Re: Application reference 6/2021/0314/FULL

Further to your letter of 15<sup>th</sup> February I am writing to express my objection to this application on the grounds of impracticality, misleading and contradictory information, increased traffic density and loss of visual amenity.

EXISTING FRONT ELEVATION

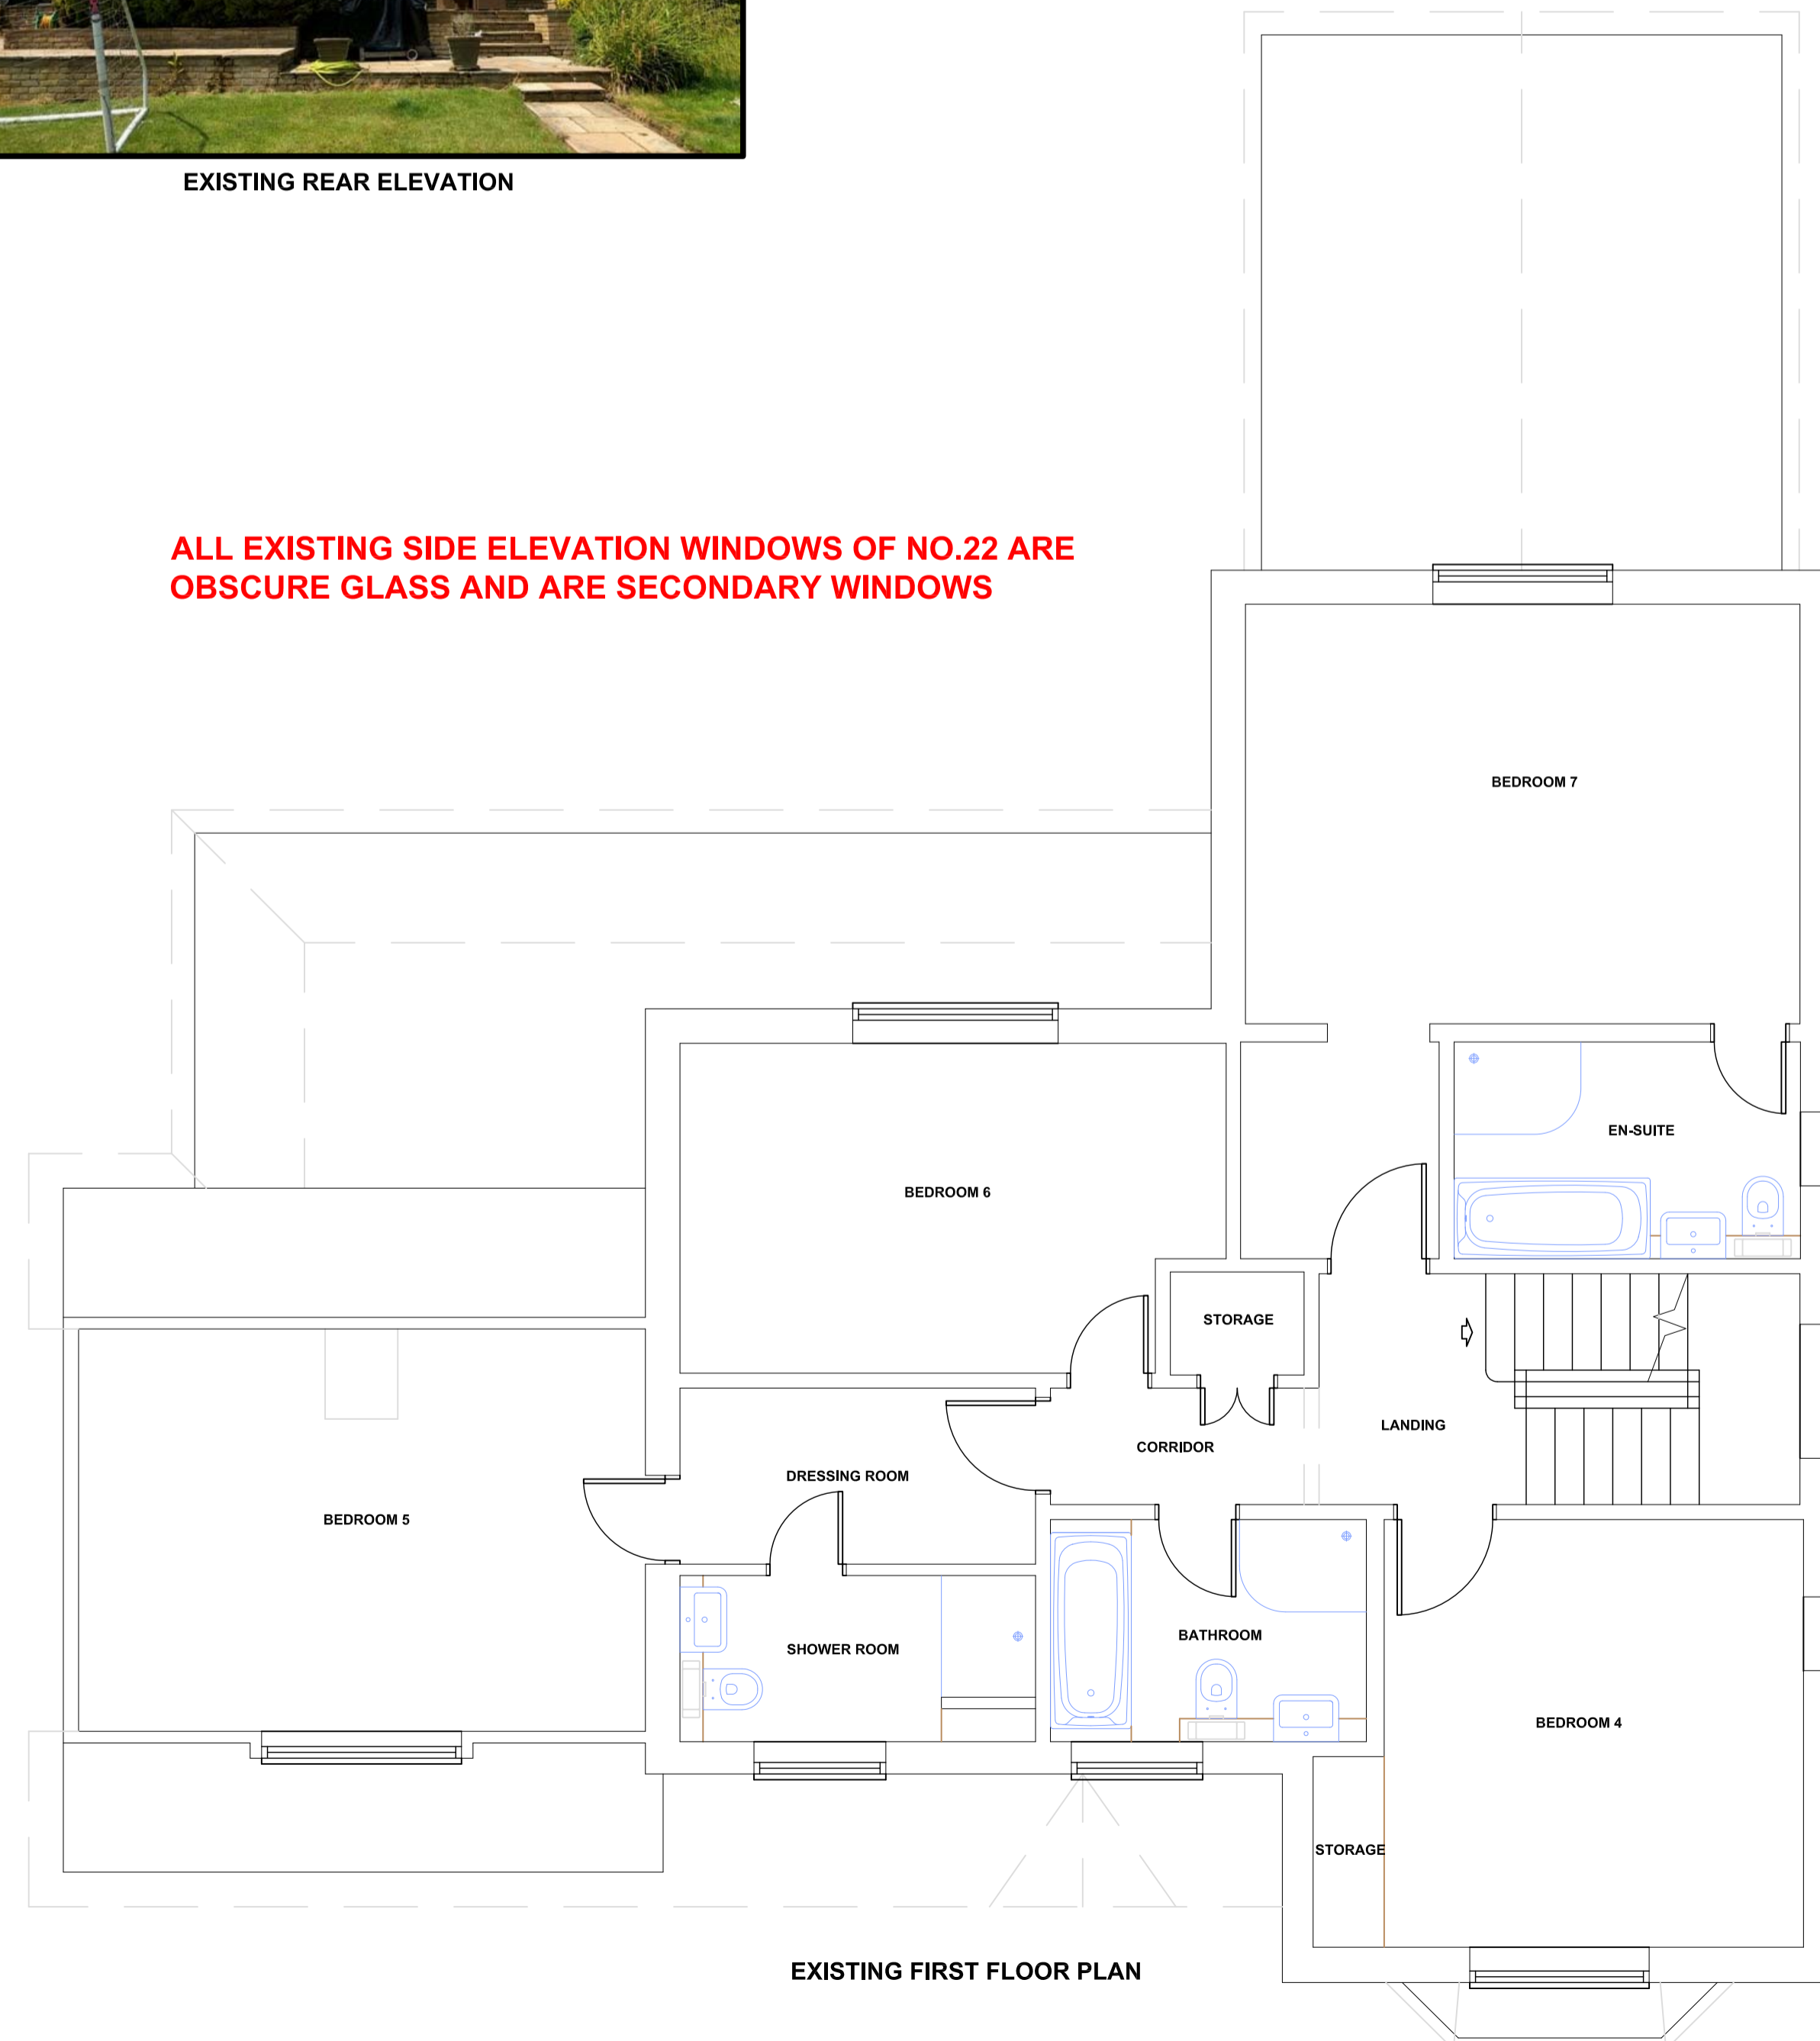
driveway to No 22 is generous and allows visiting vehicles to pull off the road (as can be seen from the plans – existing front elevation). The new property will not have this benefit and any visiting vehicle will not be able to park beside the property without blocking through traffic in Church Lane.

PROPOSED ROOF/SITE PLAN

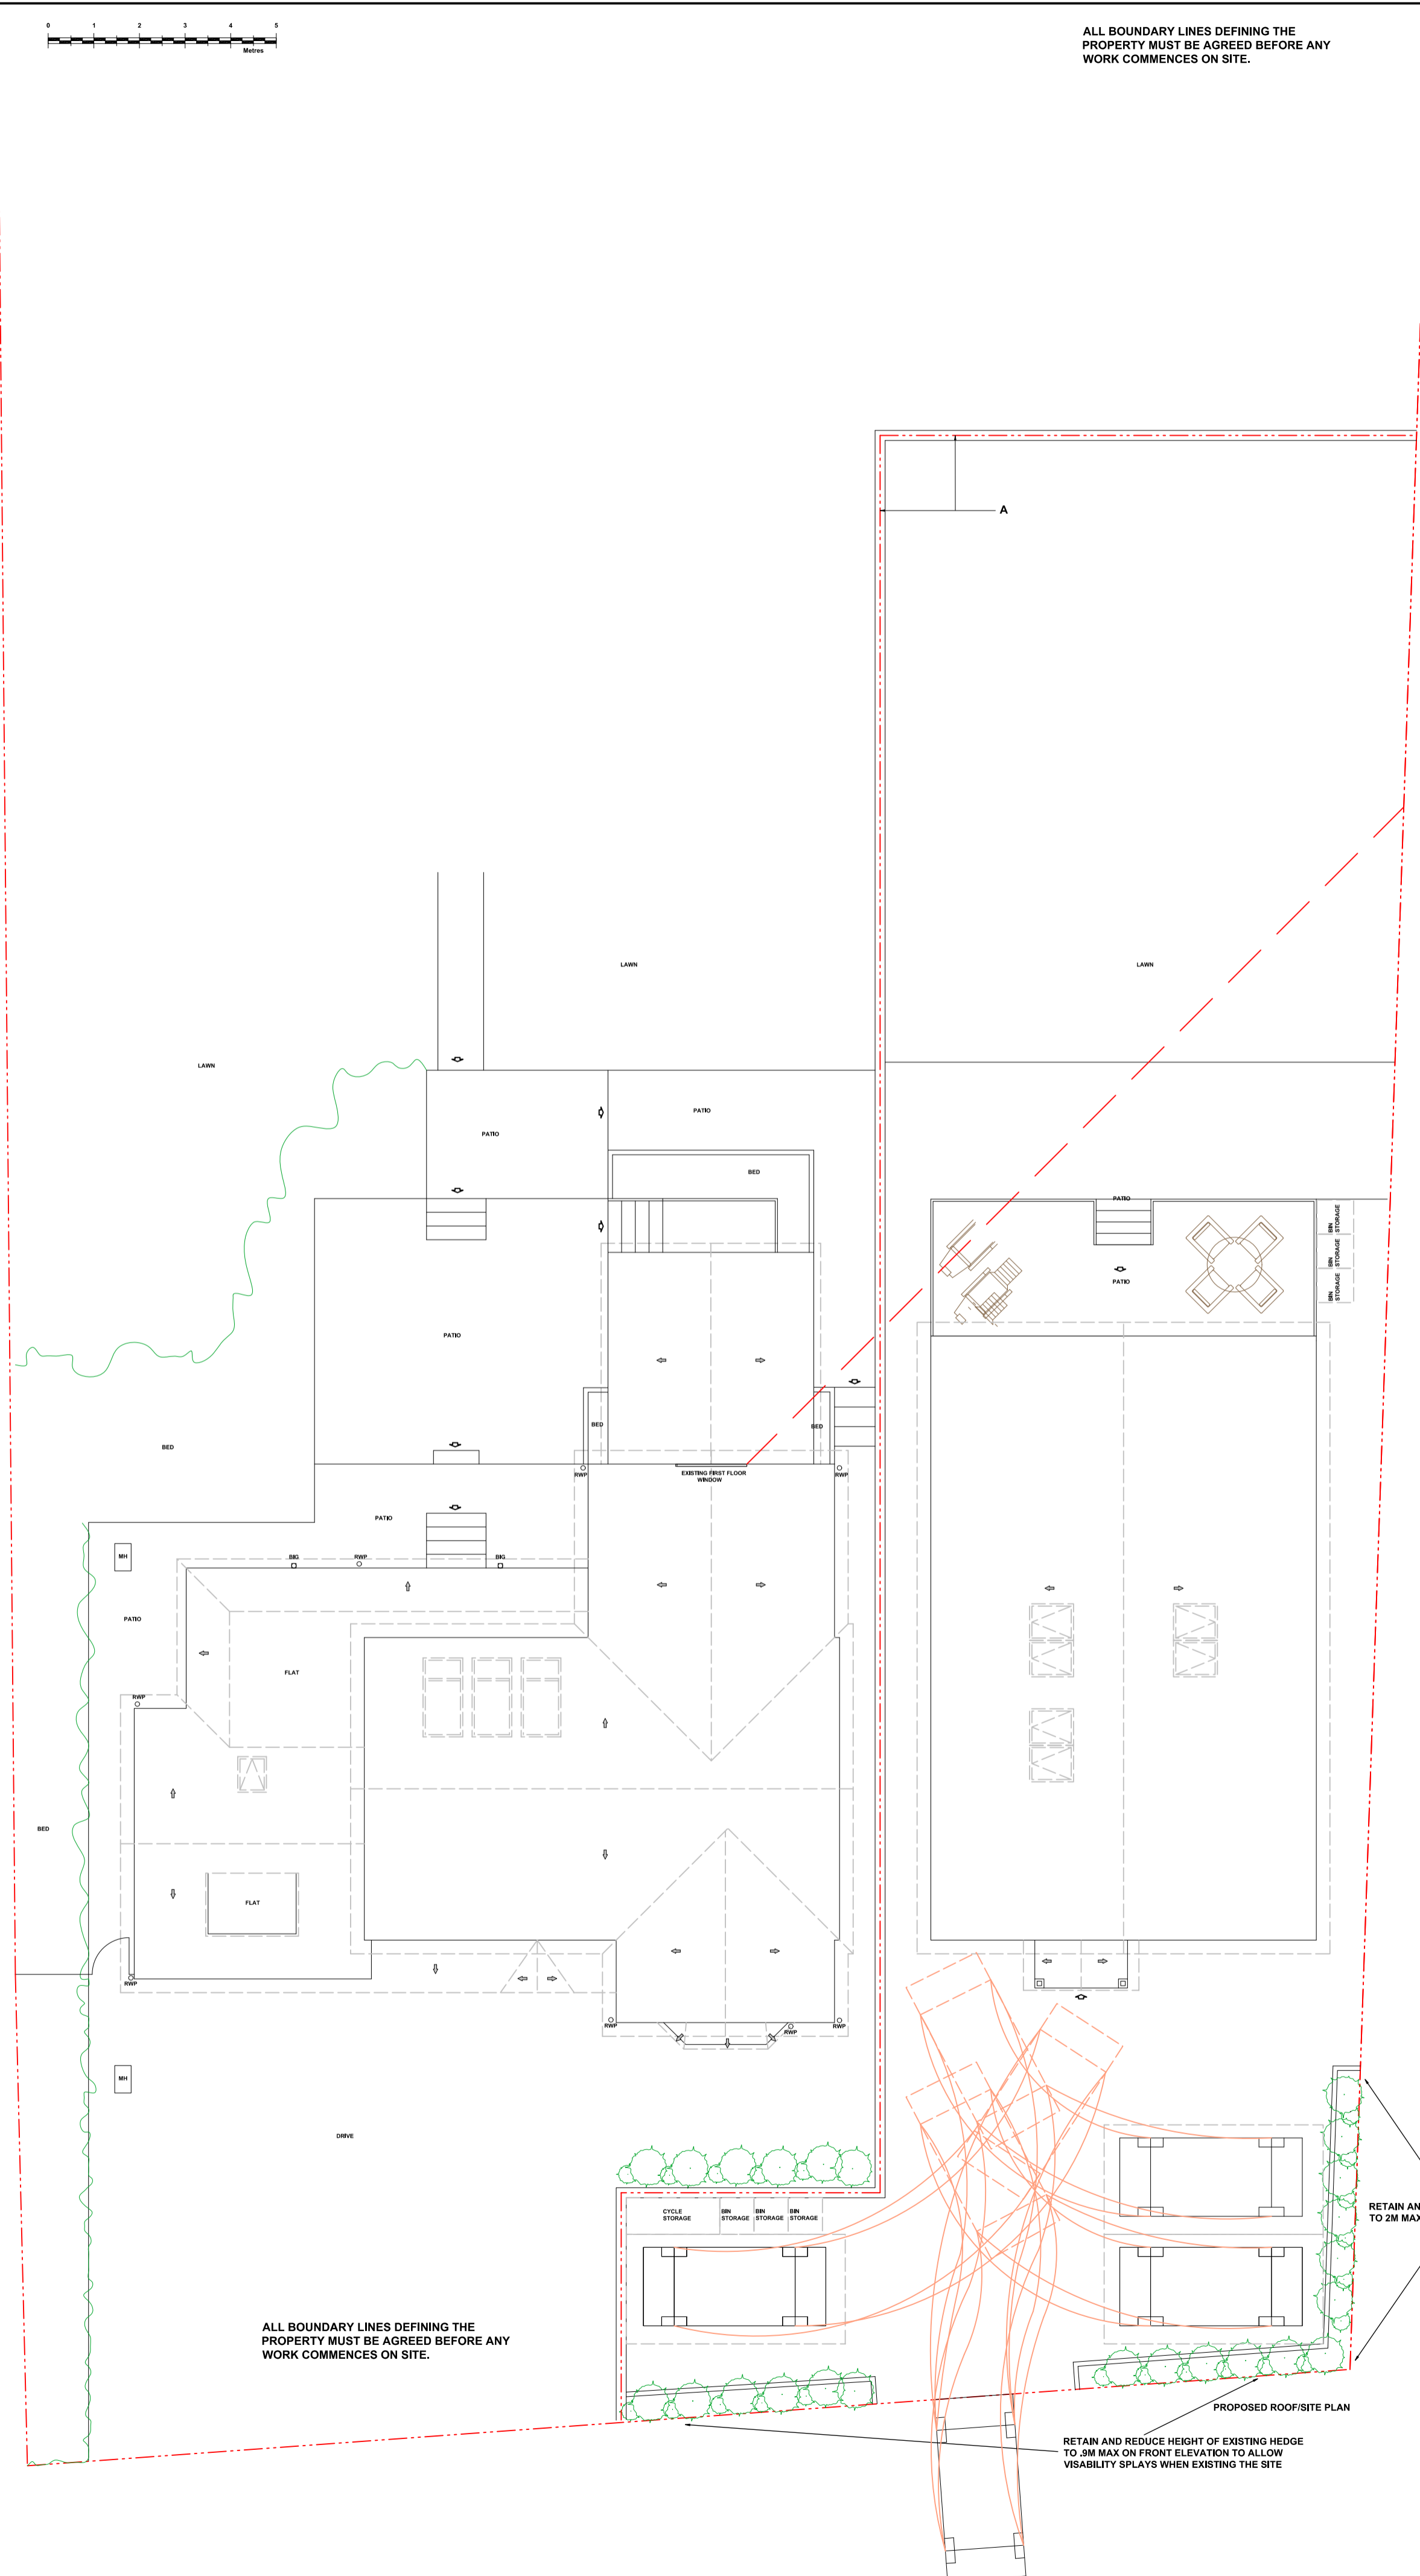
This is false information and a contradiction to the plans which clearly show a new access being created by cutting the current hedge border (see picture) and planting further hedge to separate the new property from the existing property and its existing driveway. It should also be noted that this new vehicular / pedestrian access will be created at the narrowest part of Church Lane where it will cause increased congestion. At present the

This is not true. The current border hedge contributes to the rural nature of Church Lane. The proposed removal of this hedge to create the vehicular access to the proposed new property and / or reducing its height to allow visibility for vehicles entering or leaving the public highway will greatly reduce the visual amenity of Church Lane.
